# URBAN DESIGN REPORT

**SUBJECT SITE: 116-118 CARRUTHERS AVENUE**

**REPORT DATE: NOVEMBER 15, 2024**

The following detail the comments regarding Urban Design provided at the pre-application consultation meeting that took place on June 26, 2024.

1 GROUND FLOOR
1/4" = 1'-0"

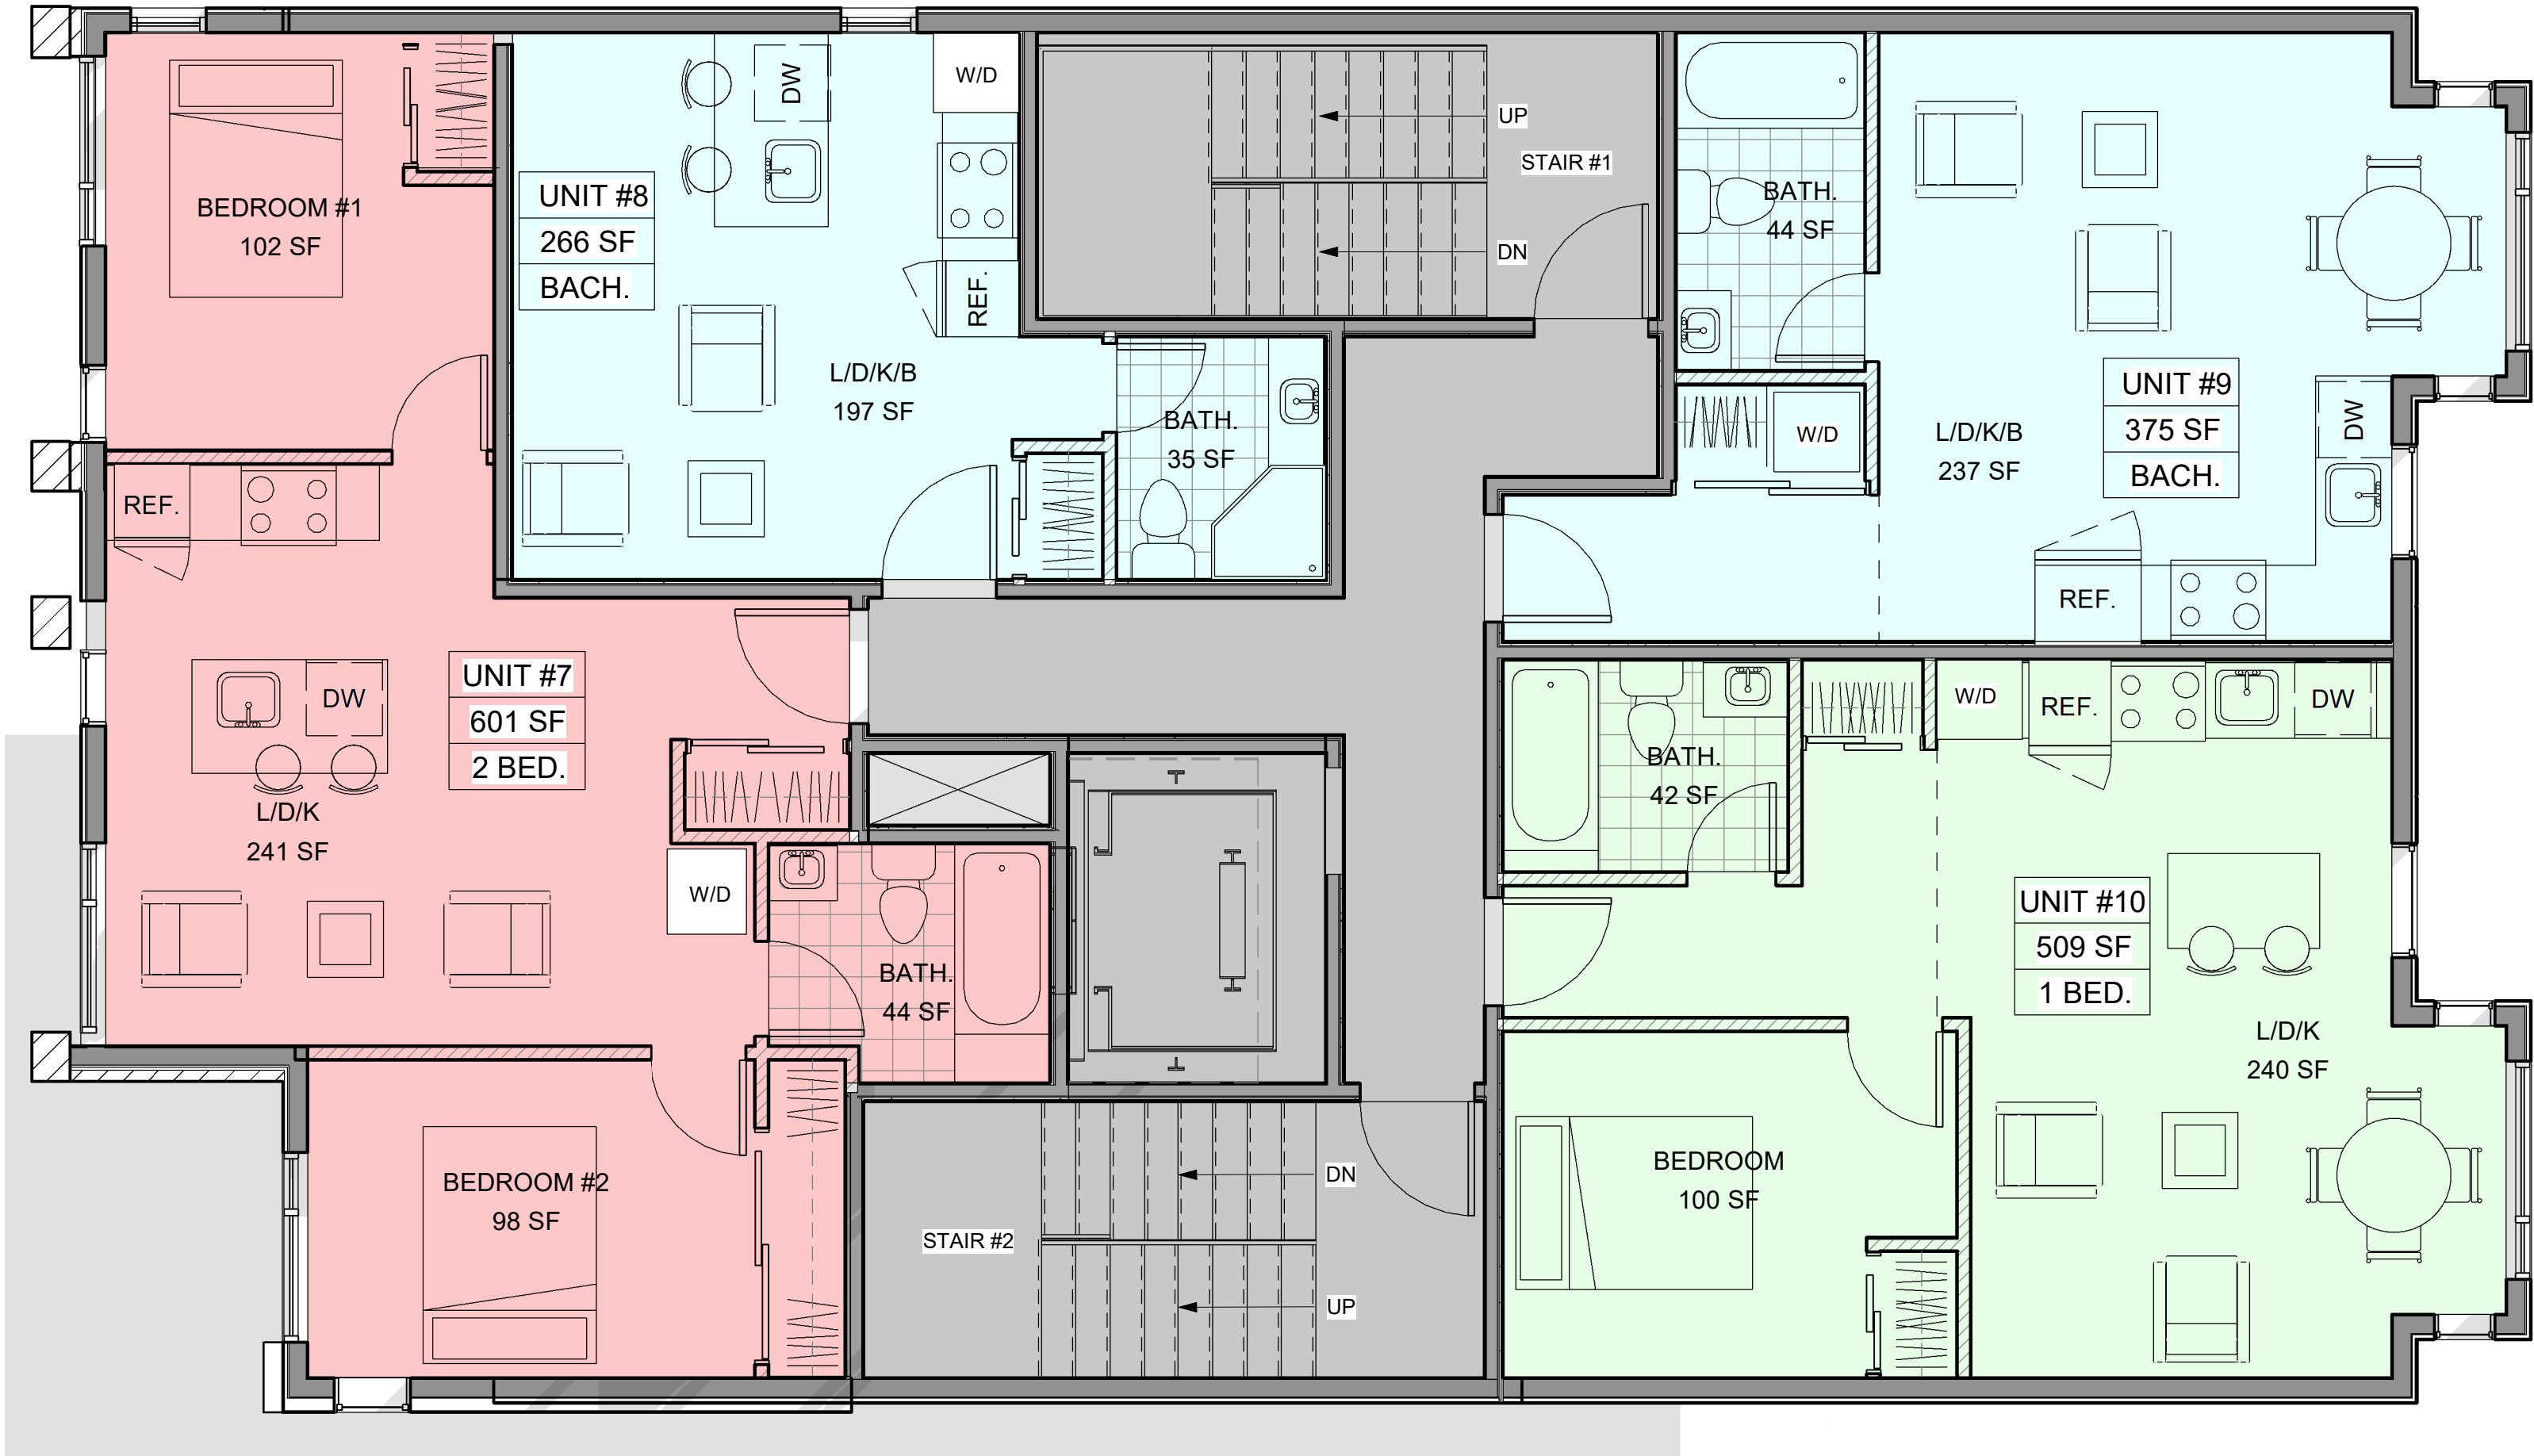
We are exceeding the 1 space per unit expectation by providing 19 bicycle parking spaces for 17 units.
Please provide floor plans to better understand the internal function of the building.	Floor plans are provided as part of the submission package.
<b>Process Comments</b>	
A Design Brief is required	Graphics provided as much as possible in addition to the required textual content.
Additional drawings and studies are required as shown on the SPIL. Please follow the terms of reference ( <a href="#">Planning application submission information and materials   City of Ottawa</a> ) to prepare these drawings and studies. These include (i.e., The UDRP drawings):  <ul style="list-style-type: none"> <li>- Landscape Plan.</li> <li>- Elevations</li> </ul>	<ul style="list-style-type: none"> <li>- Design Brief provided (this document)</li> <li>- Site Plan (provided)</li> <li>- Landscape Plan (provided)</li> <li>- Elevations (provided)</li> <li>- Landscape Plan (provided)</li> </ul>

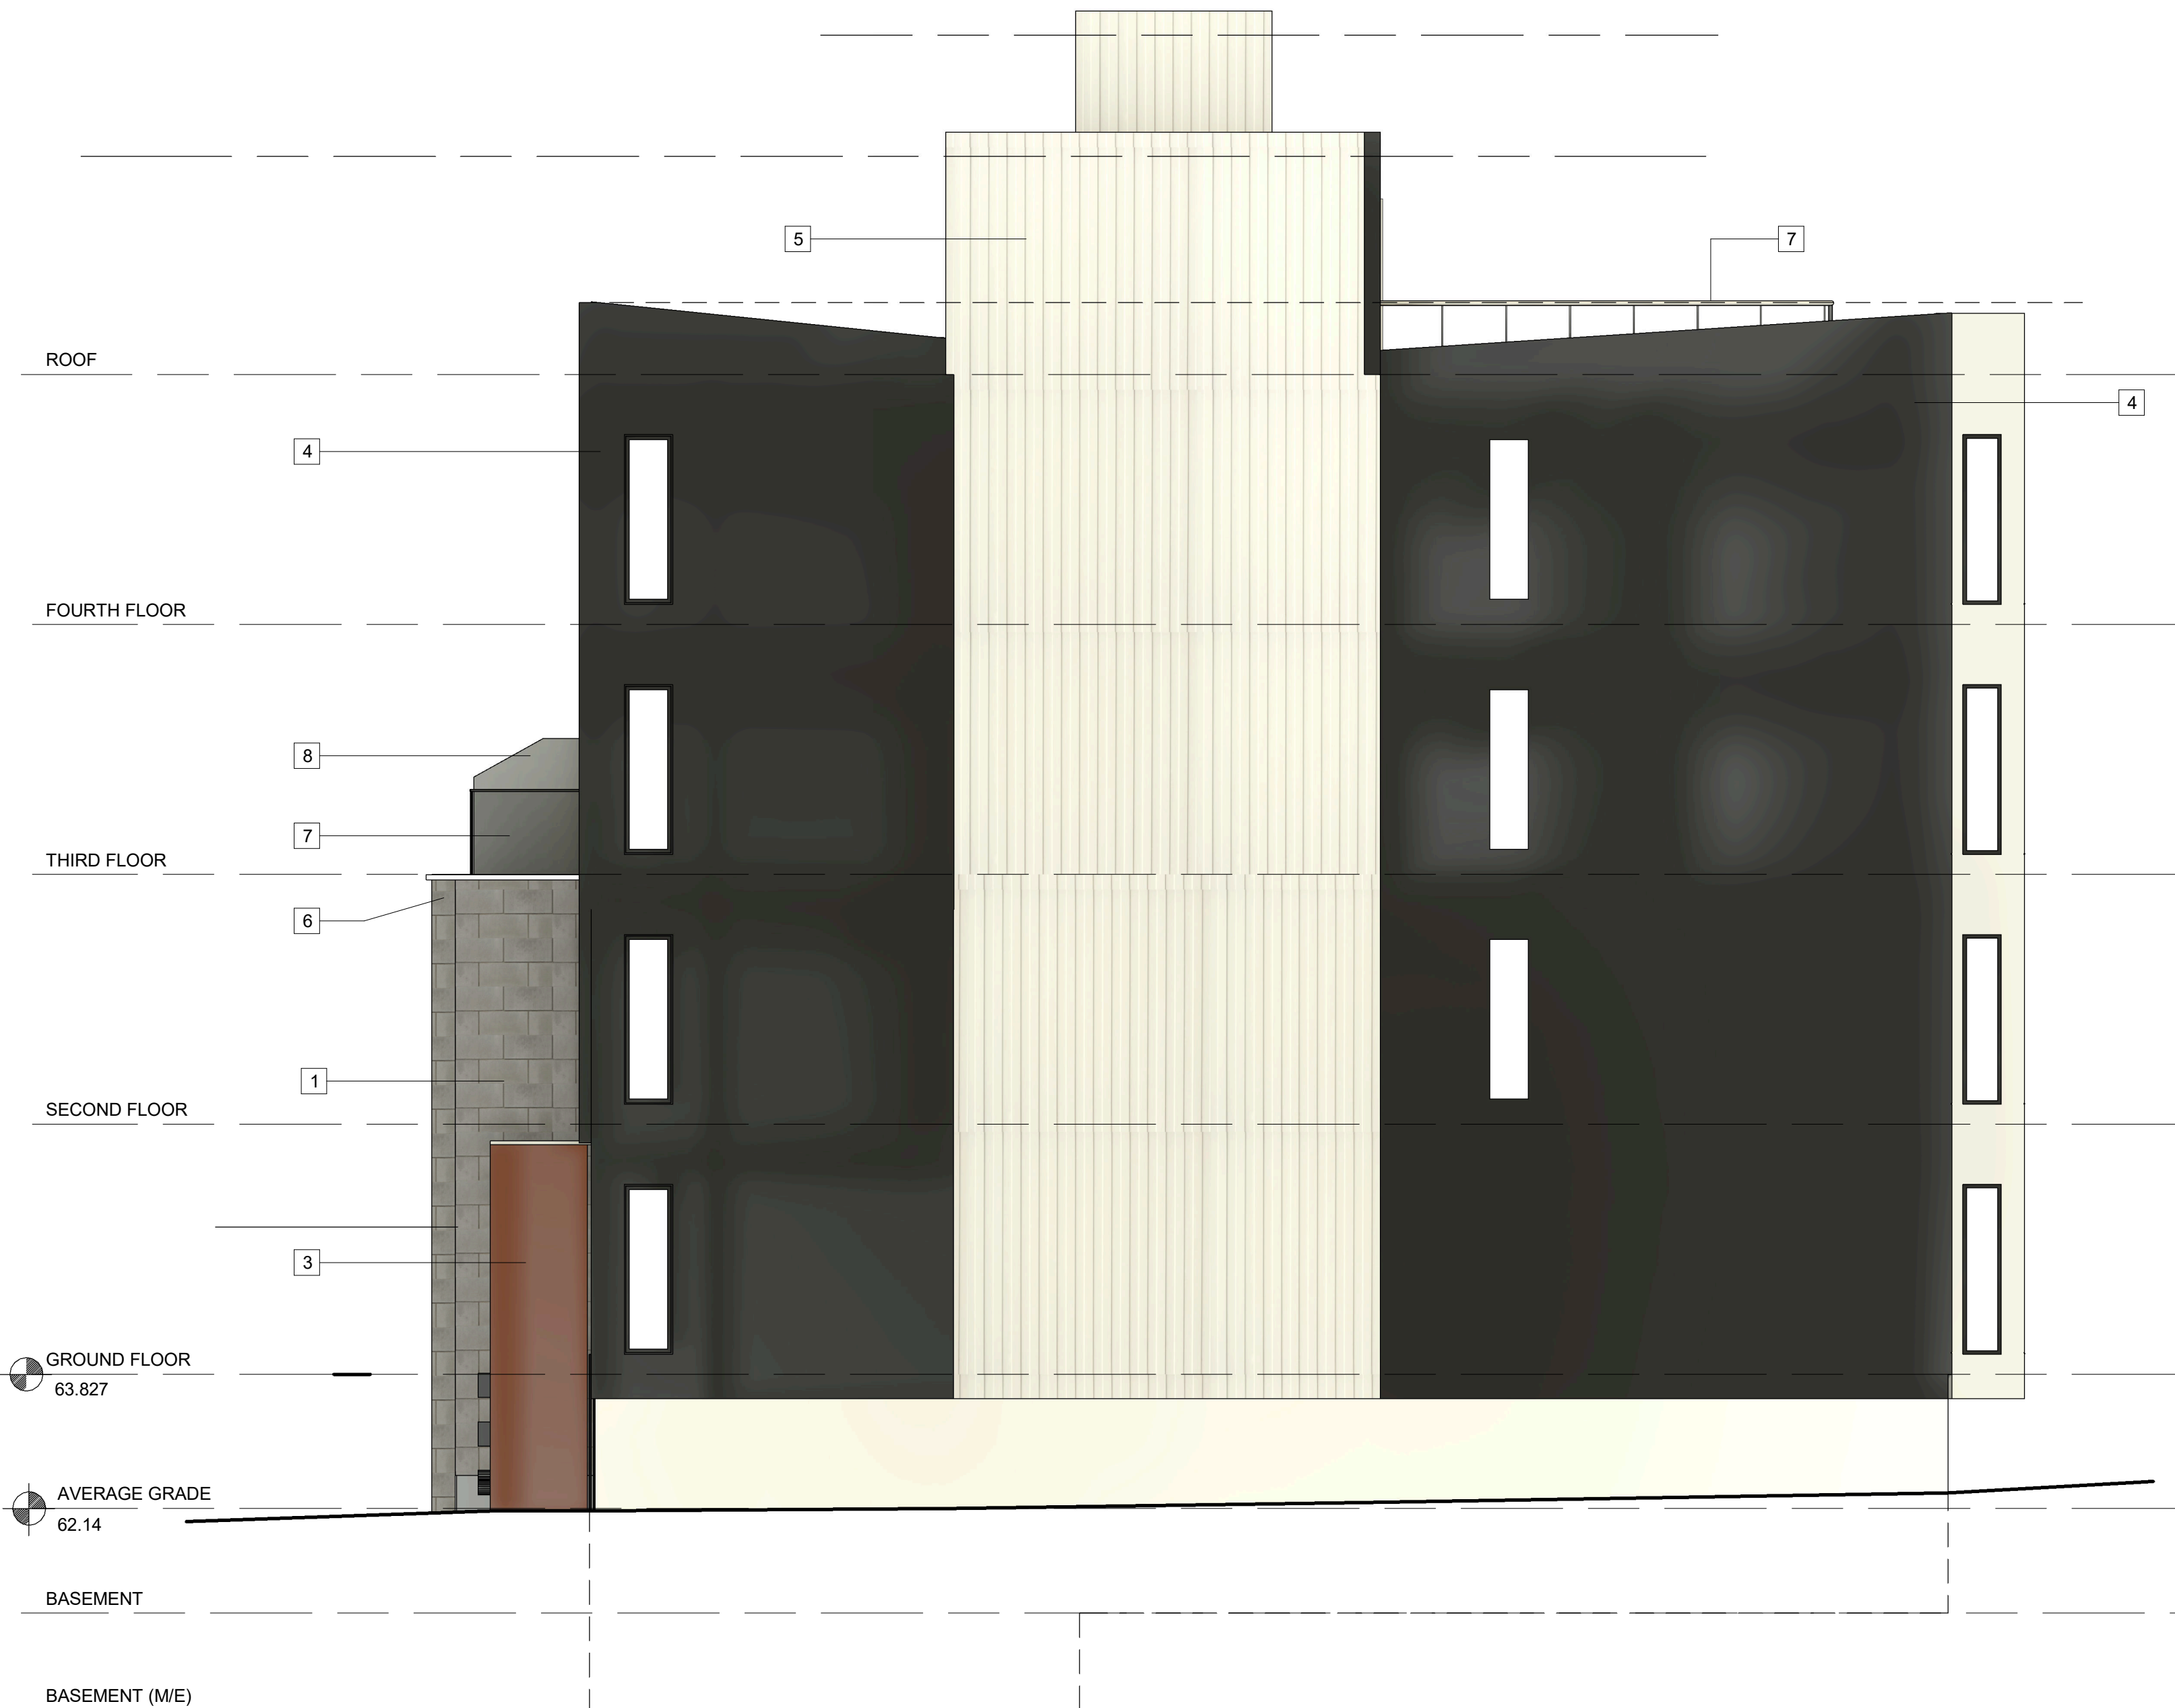
Please clarify and indicate proposed materials.	Materials include stone veneer, metal panel (light grey, dark grey, brown), vertical metal panel (light grey), precast parapet cap, opaque glass railing, opaque fence, bird safe glass. The location of the material are shown on the elevation drawings.
The 2.44m right of way should be removed and replaced with landscaping. Please see Section 140(6)(a) of the Zoning By-law. As the property abuts a rear travelled laneway, an additional driveway from Carruthers Avenue should not be provided. Solid, permanent features to prevent parking in the front yard will be required.	This right-of-way is an easement in favour of the neighbouring property owner for access to their building. They have requested that it be maintained. We have replaced it with landscaping.
Please consider the location of the proposed visitor parking space in the rear yard and ensure that unnecessary hardscape is limited.	The visitor parking space is sited so that it takes up the minimal amount of hardscape as possible. We will be maximizing soft landscaping where possible on the site.

<p style="text-align: center;"><b>Recommendations</b></p>	
<p>We recommend the materiality of the side elevations be a cementitious product which is more compatible with a residential neighbourhood (as opposed to a very large wall of corrugated metal which gives an industrial look and will be very visible in the neighbourhood).</p>	<p>No corrugated metal is used. Metal panel is proposed.</p>
<p>We recommend taking advantage of the additional side yard separation to the south to increase glazing and make the units more livable.</p>	<p>Windows are used as many as possible on the south side of the property. In the future we will adjust window size and locations depending on unprotected opening calculations.</p>
